**Section 96A of the Town & Country Planning Act 1990 (as amended)
Town and Country Planning (Development Management Procedure) (England) Order 2015
(as amended) - Article 10**

Non-material amendment following grant of A/219/17/PL to:-

Land East of Mayflower Way Windy Ridge Angmering BN16 4AY

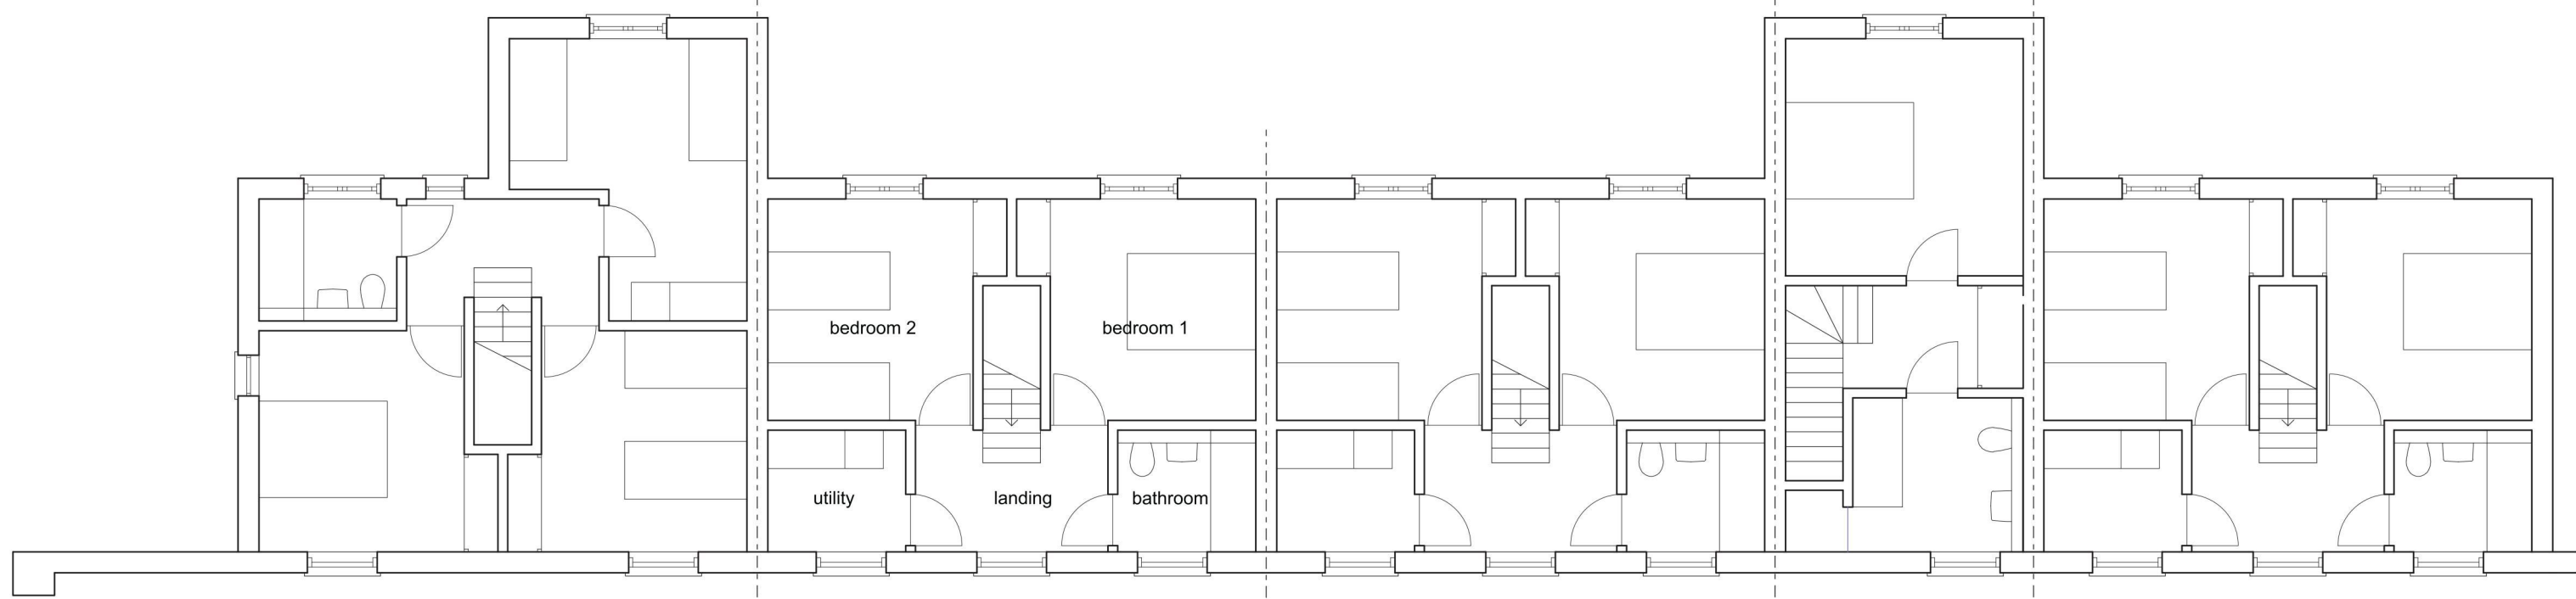
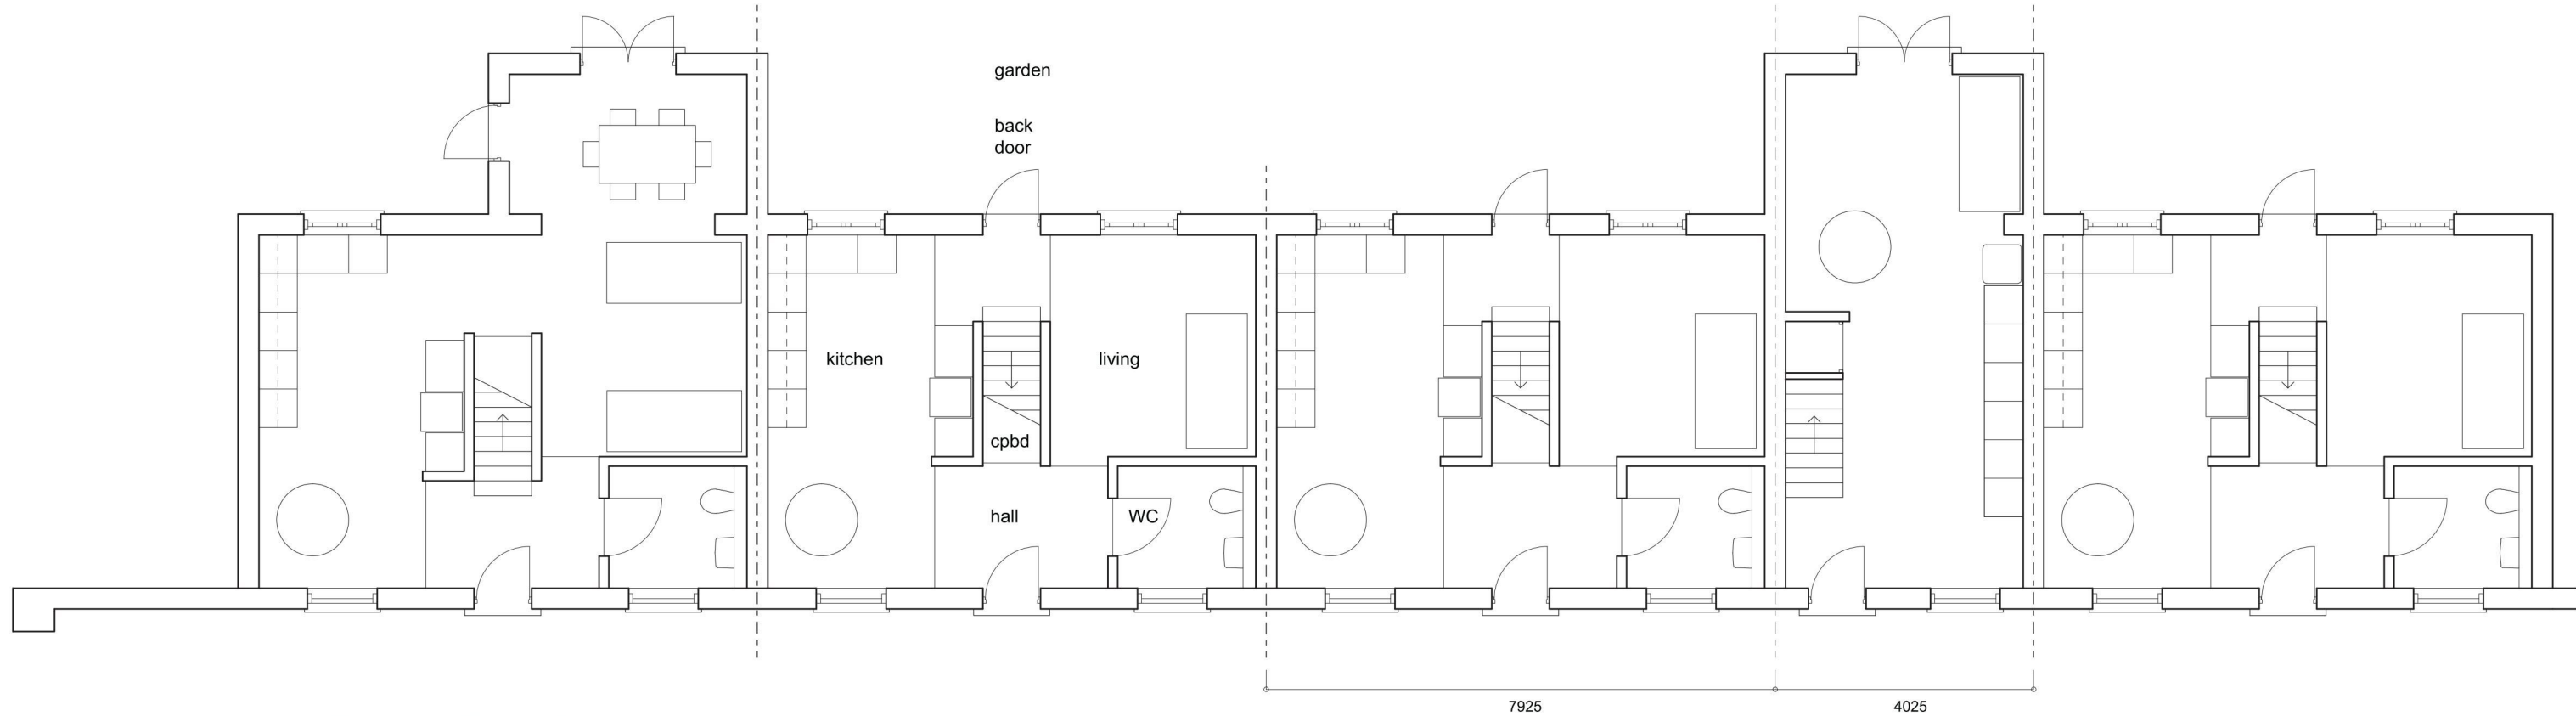
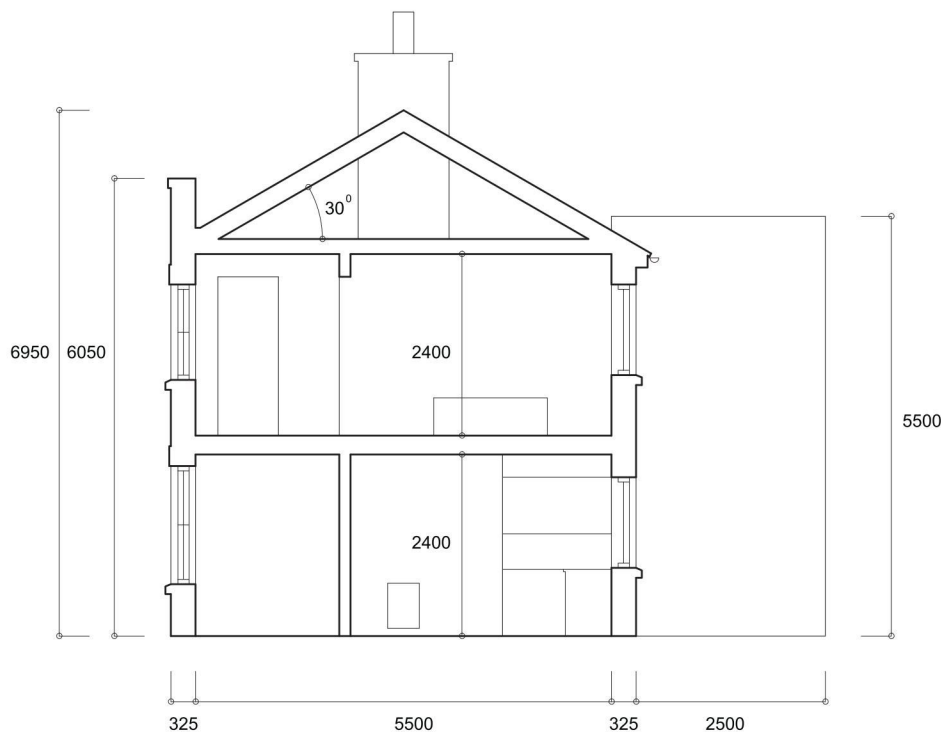
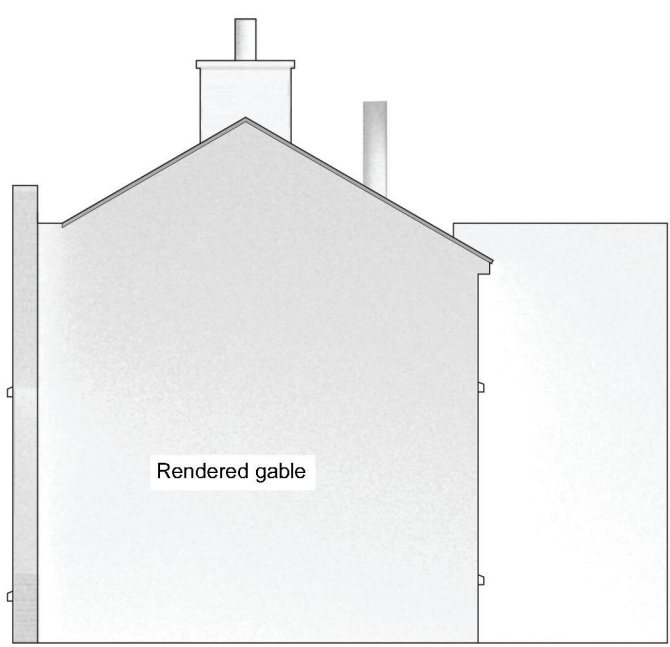
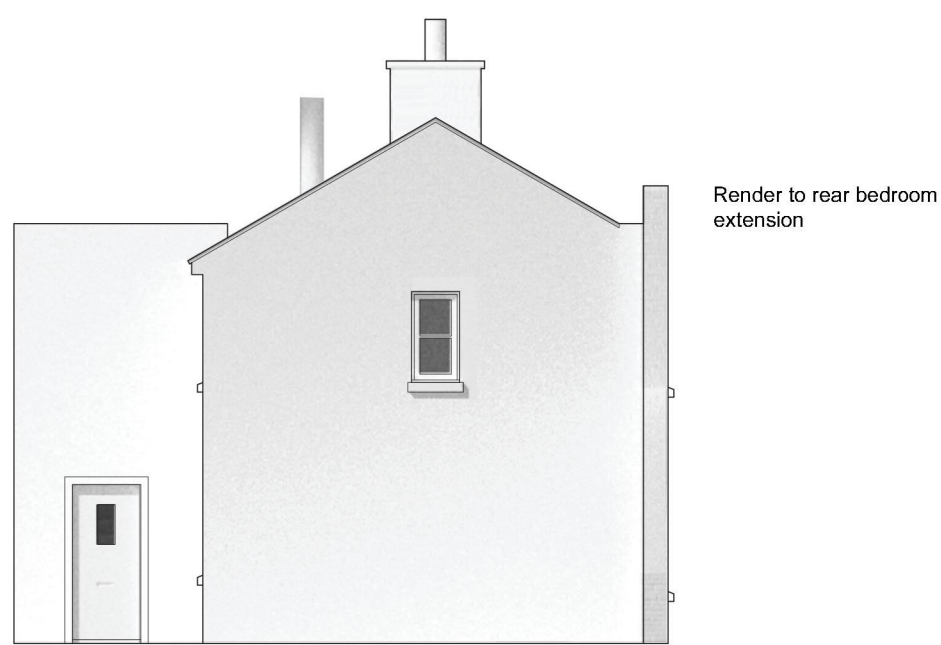
1 - to remove the galvanised steel flues however all chimneys will remain but non-functional, with traditional masonry flues (pots), 2 - roof tiles shown as clay pantiles will be changed to concrete pantiles while providing the same overall appearance, 3 - roof tiles to be artificial Slate providing the same overall appearance, 4 - rainwater goods to be black PVCu with cast Iron effect, 5 - windows to be PVCu white providing the same overall appearance, 6 - front doors to be GRP composite PAS24 while providing the same overall appearance, 7 - Lintol treatment amended where noted on drawings: RSJ detail changed in favour of homogenous brickwork, & window lintol treatment amended as noted,

17.319-P01 Rev A Terrace A Floor Plans and Elevations
17.319-P02 Rev A Terrace B Floor Plans and Elevations
17.319-P03 Rev A Terrace C Floor Plans and Elevations
17.319-P04 Rev A Terrace B 2 Bed Detail Floor Plans and Elevations
17.319-P05 Rev A Terrace B 3 Bed Detail Floor Plans and Elevations
17.319-P06 Rev A Terrace A 1 Bed Detail Floor Plans and Elevations
17.319-P07 Rev A Terrace C Flats Detail Floor Plans and Elevations
